OFFICIAL NOTIFICATION OF DECISION

Project# PR-2020-004414

Application#
SI-2020-00917 SITE PLAN – DRB
VA-2020-00437 WAIVER – SIDEWALK WIDTH
VA-2020-00436 WAIVER – SIDEWALK LOCATION
VA-2020-00435 WAIVER – CUL-DE-SAC

On November 18, 2020, the Development Review Board (DRB) held a public meeting concerning the above referenced applications and approved the requests, with delegation to ABCWUA and Planning, based on the following Findings:

**AS100**

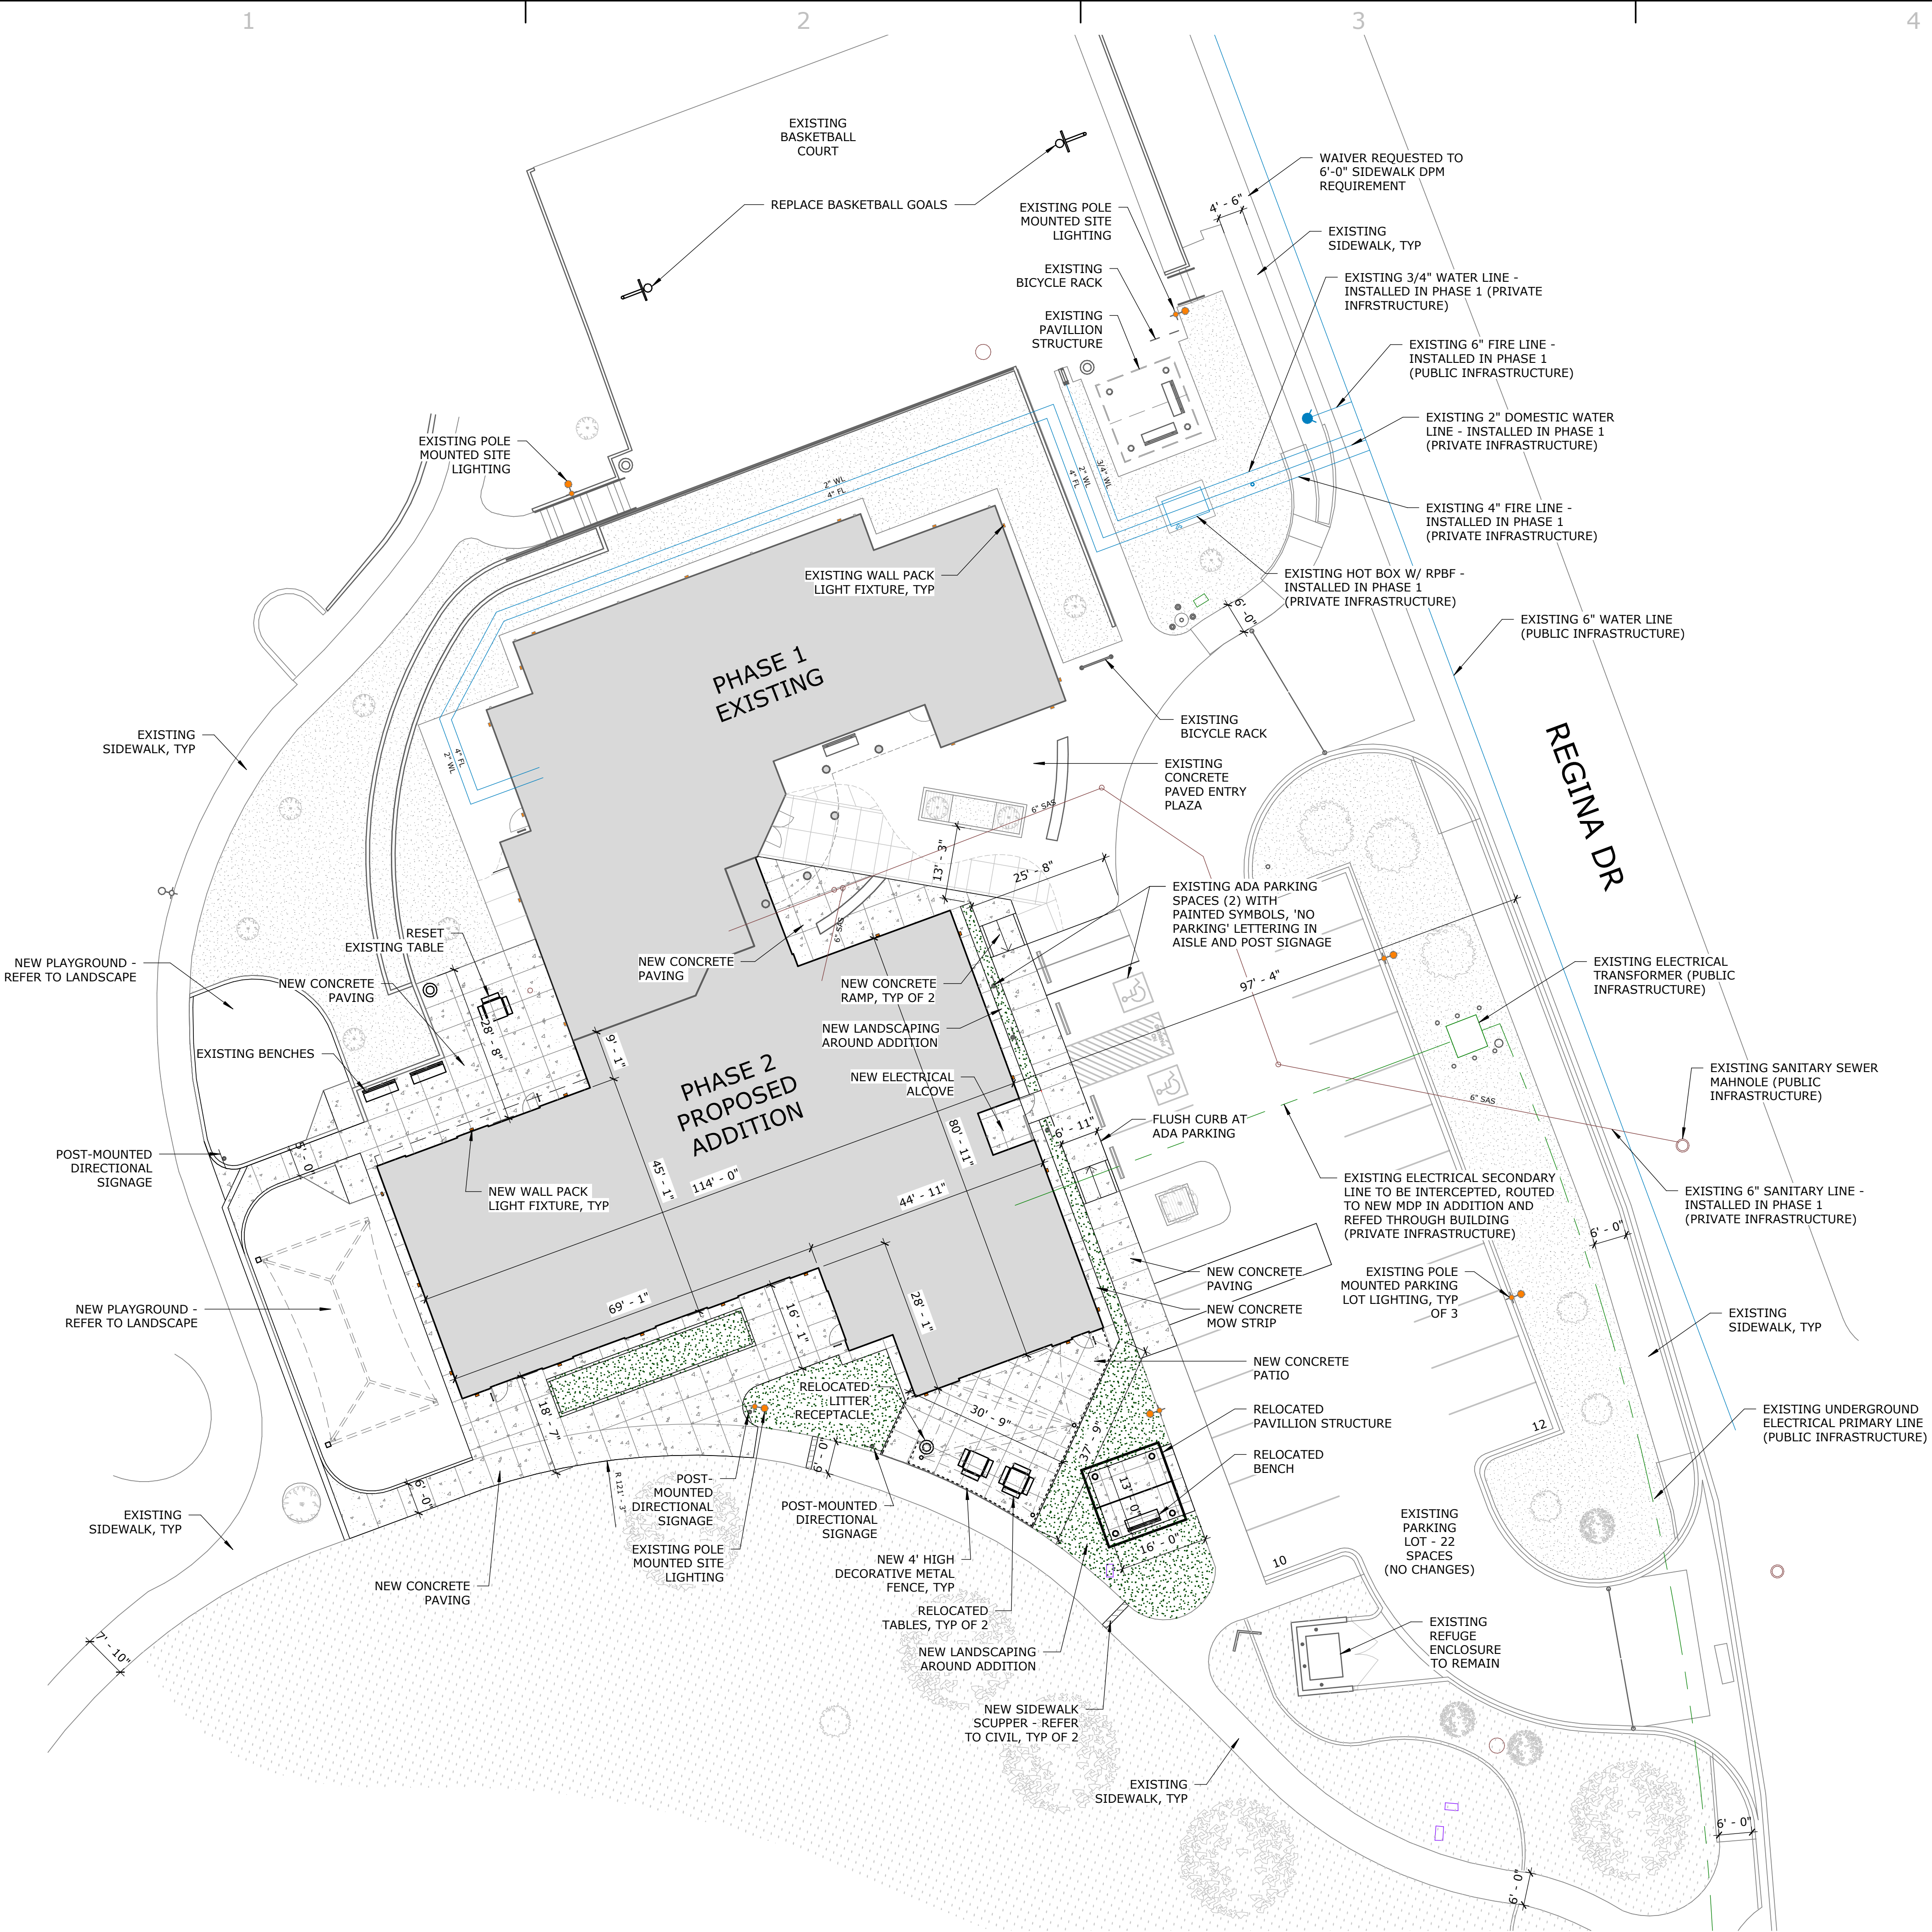
- 1. This Site Plan is valid 5 years from DRB approval (11/18/2020). An extension may be requested prior to the expiration date.
- 2. Final sign-off is delegated to ABCWUA for removal of Sheets C202, C203, and C204, and inclusion of a note on Sheet AS100 that indicates the proposed building will connect with the existing services.
- 3. Final sign-off is delegated to Planning for the Solid Waste signature, removal of the detectable warning surface from the curb ramp detail on behalf of Transportation, and the addition of post-mounted signage on the south and west side of the building directing visitors to the east entrance.
- 4. The applicant will obtain final sign-off from ABCWUA and Planning by January 18, 2021 or the case may be scheduled for the next DRB hearing and could be denied her the DRB Rules of Procedure.
